TILBURY2

OXFORD BROOKS UNIVERSITY INDEPENDENT REVIEW OF
TILBURY2 CUMULATIVE IMPACT ASSESSMENT

FINDINGS OF INDEPENDENT PEER REVIEW

Report ref v1.2
27th July 2018

Drawing file: TR030003 / TR030003-000395-6.3 Figures and Drawings - Figure 11.8 Projects Considered In the Cumulative Assessment.pdf

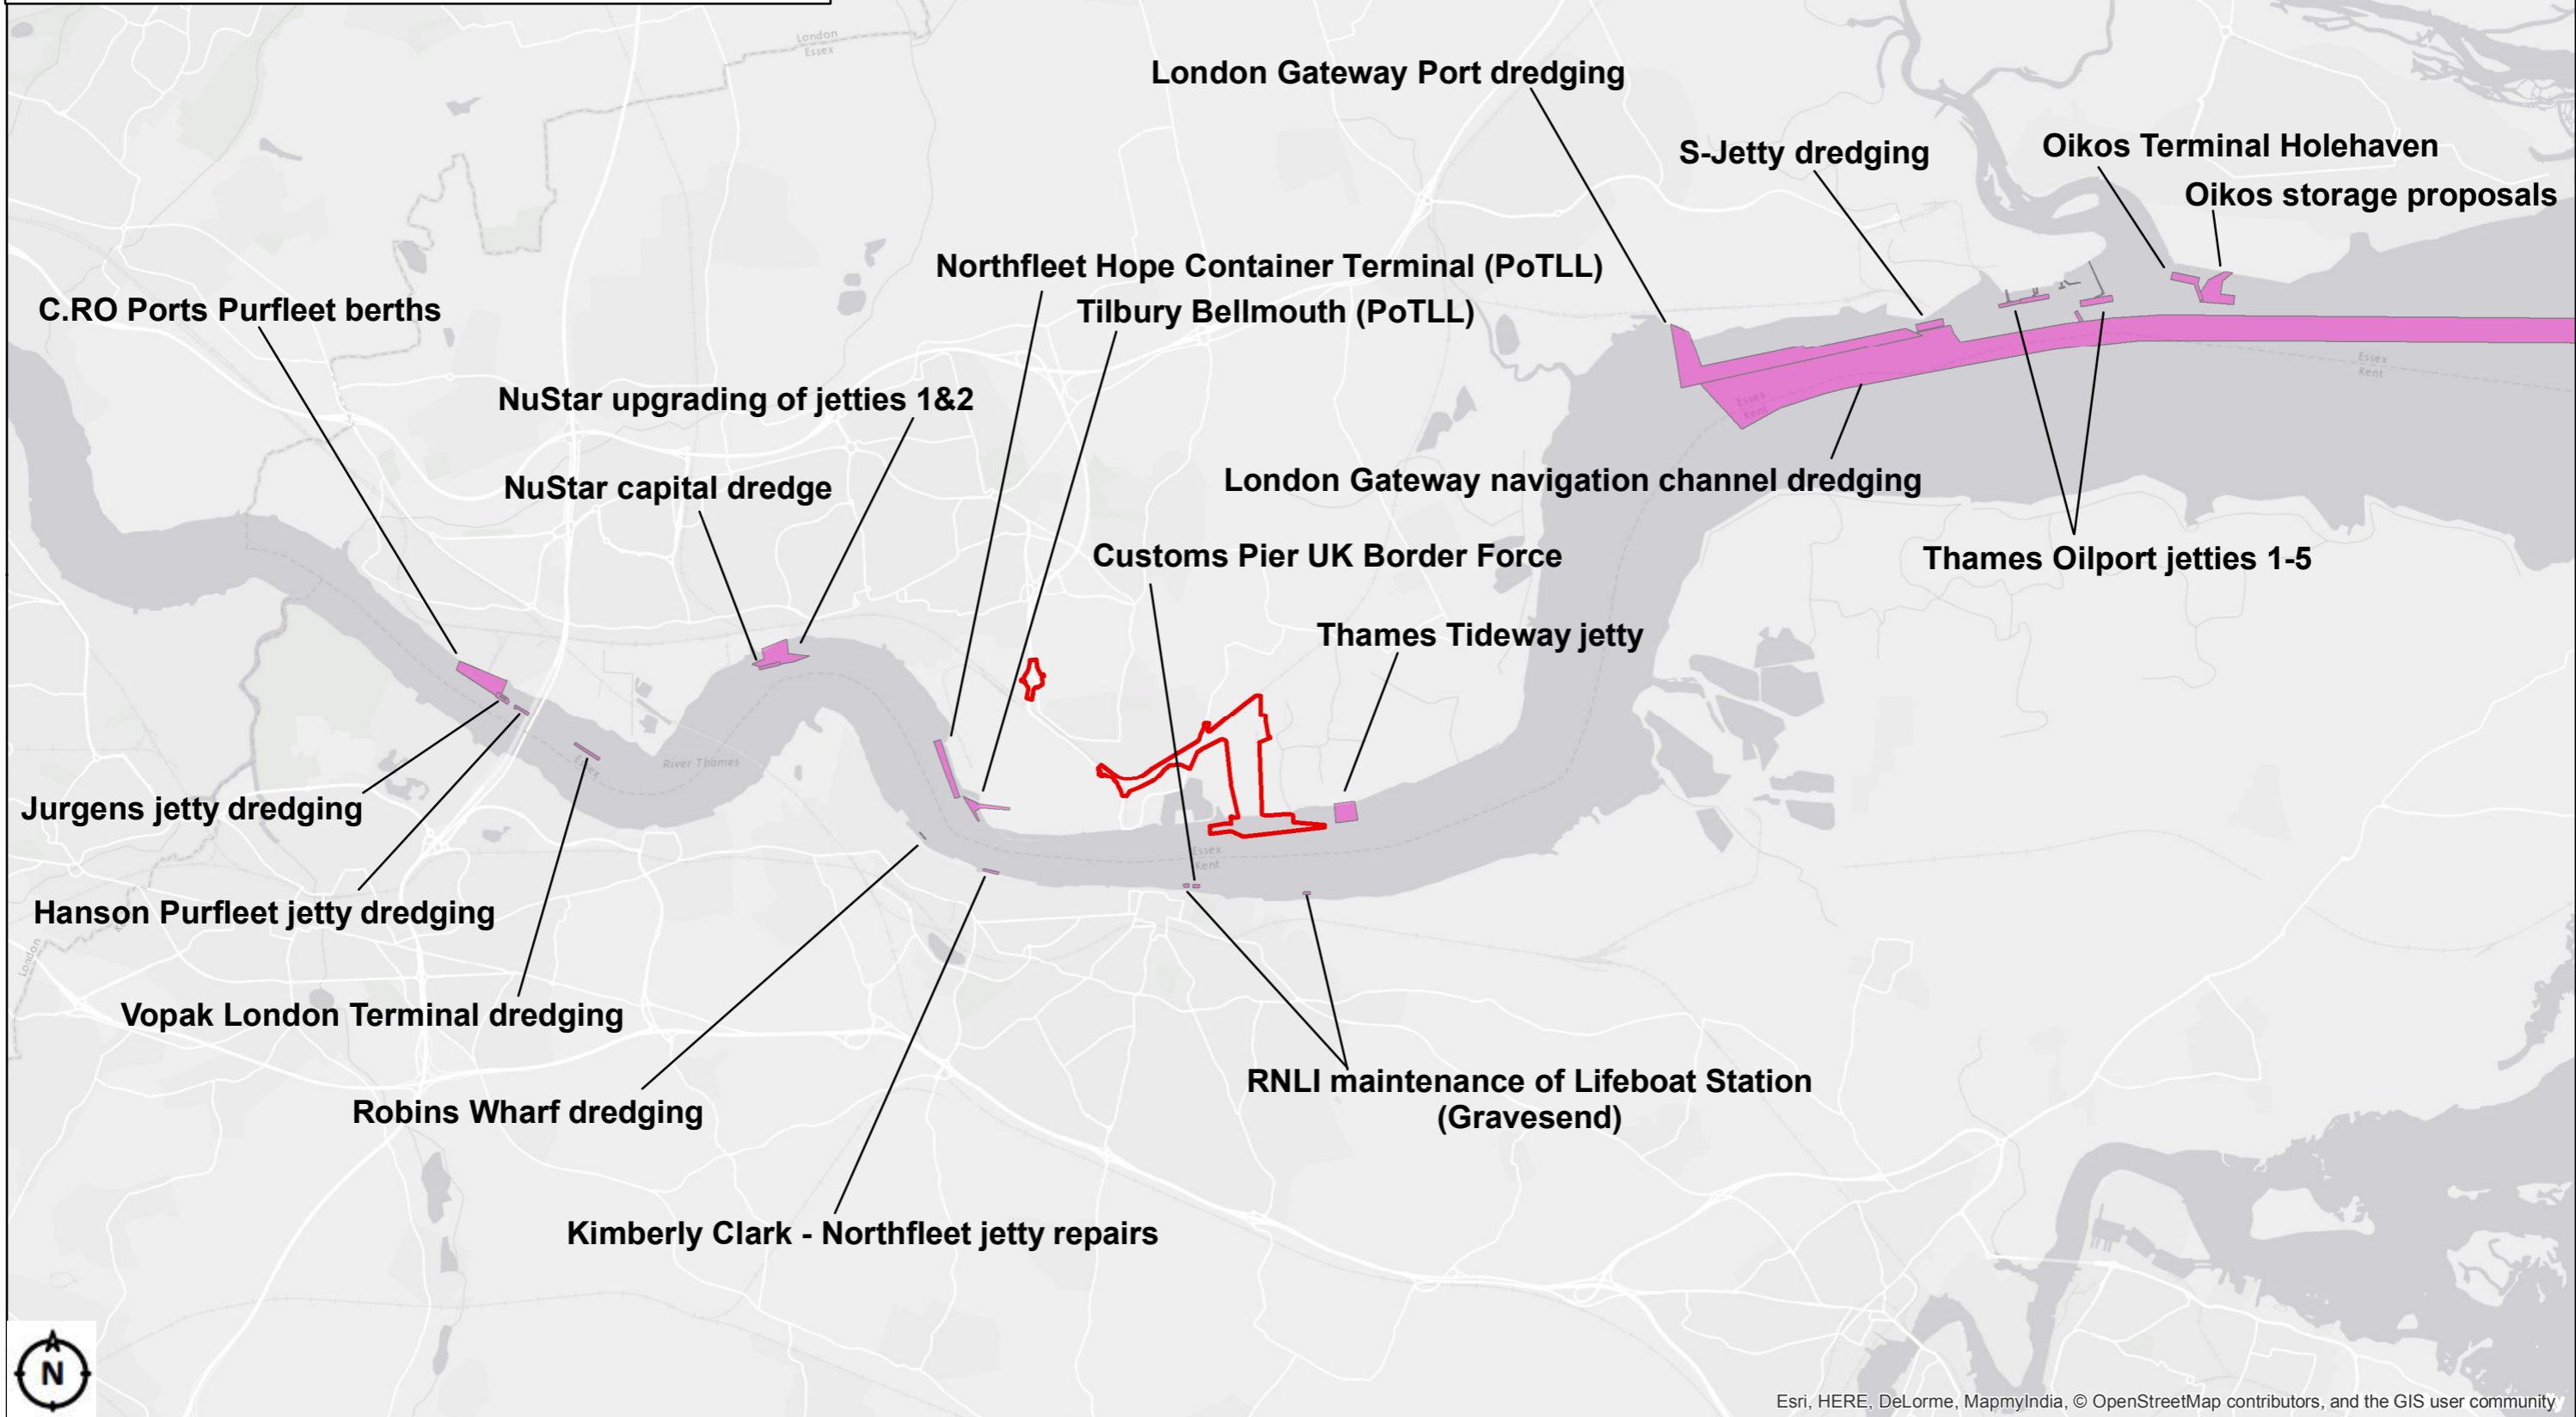
<p>13) Is there a map of RFFPs?</p>	<p>APP-097 May 2017 Figure 2-1 did not include LTC or TEC; APP-148 Figure 11-8 dredging CEA; REP3-027 May 2018, Appendices 1-3</p>	<p>C</p>
--	--	-----------------
